Appendix B – Submissions Response Table (SSD- 65924461)

Bayside Council		
Council has reviewed the submitted documentation and raises several objections, below. These objections are predominantly due to a level of missing or incomplete information to demonstrate how the proposal in its current form is suitable for the site and within the locality, and how some site-specific environmental issues will be managed. It is requested that the Applicant provides additional information to address Council's concerns.	Noted. See below.	N/A
Built Form		
<u>1. Site Analysis / Context</u> A detailed analysis has been provided to outline the primary constraints and opportunities of the site, establish fundamental principles for the development and explore several design options for the site. However, the architectural drawings still lack context as the proposed building is largely shown in isolation, and no elevation or section has been provided to show how the proposal relates to the low-density residential context of Stephen Road. A clear and accurate depiction of how the proposal relates to the low-density residential context of Stephen Road has not been provided.	An updated set of Architectu

1 NORTH 1:450

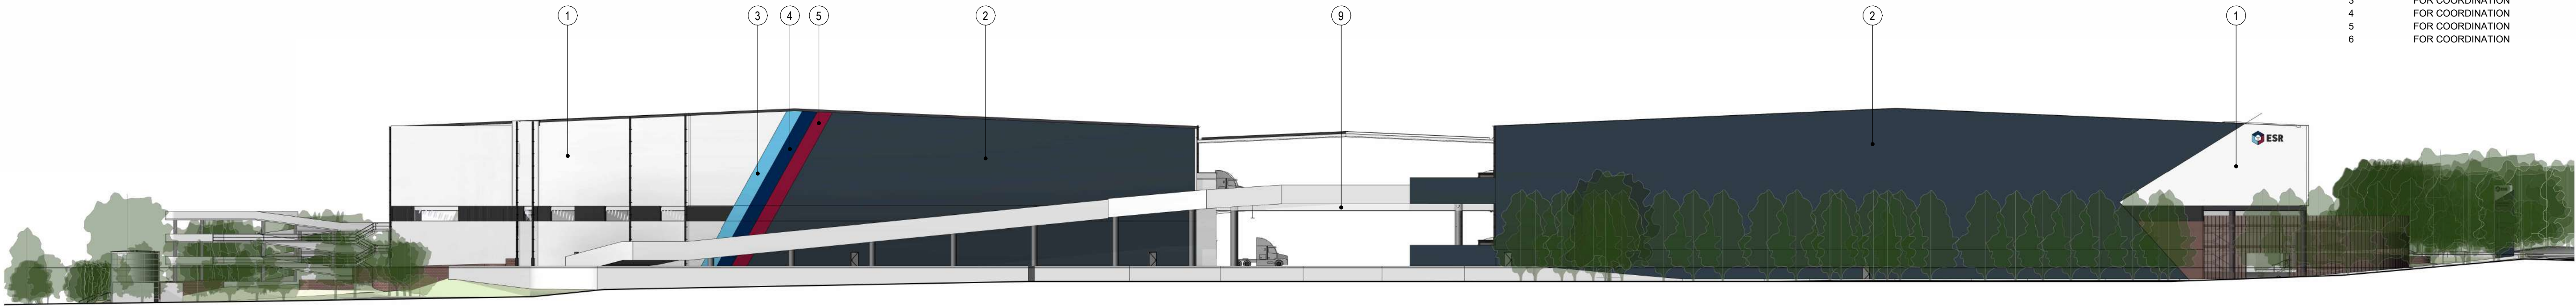
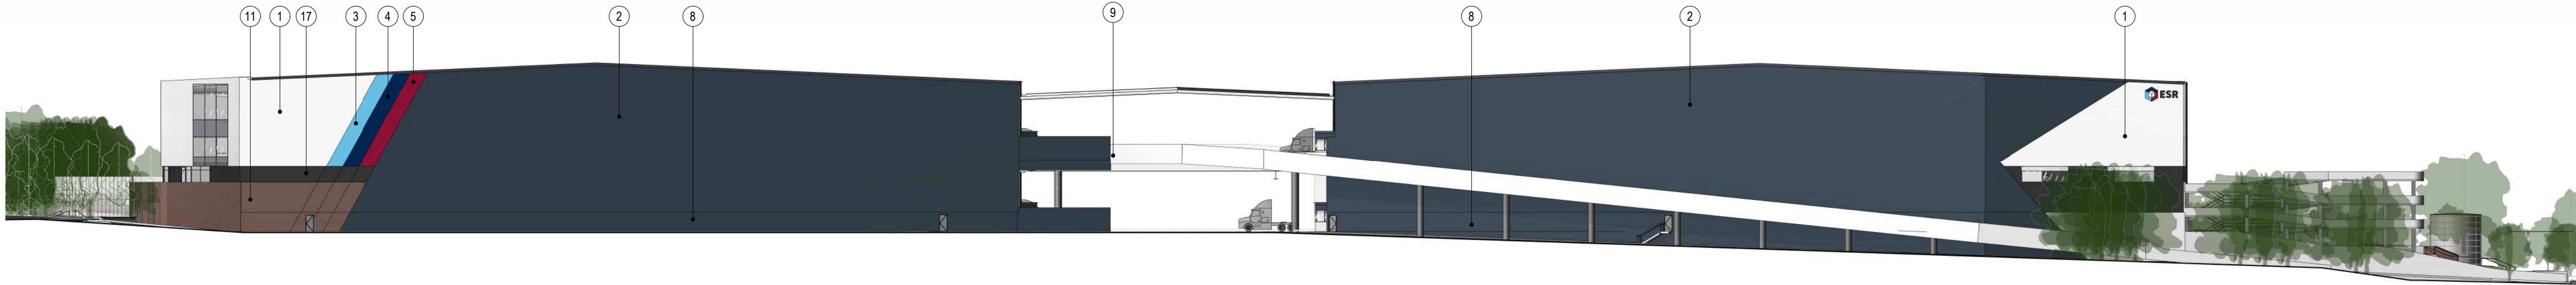
5. The eastern façade of the building presents as a 'back of house' elevation, despite being clearly visible from Coal Pier Road. This includes unsightly views of the underside and structural supports of the three storey spiral heavy vehicle ramps. Given the building's considerable size, the eastern elevation must be reviewed to provide a more 'front' facing façade due to its exposure to the public domain.	The viewpoints from Coal Pier Road provided in the Visual Impact Assessment show the revised design resulting in a significantly softer visual impact, with the Year 15 impact being broadly comparable with the existing vegetated condition.	Appendix F
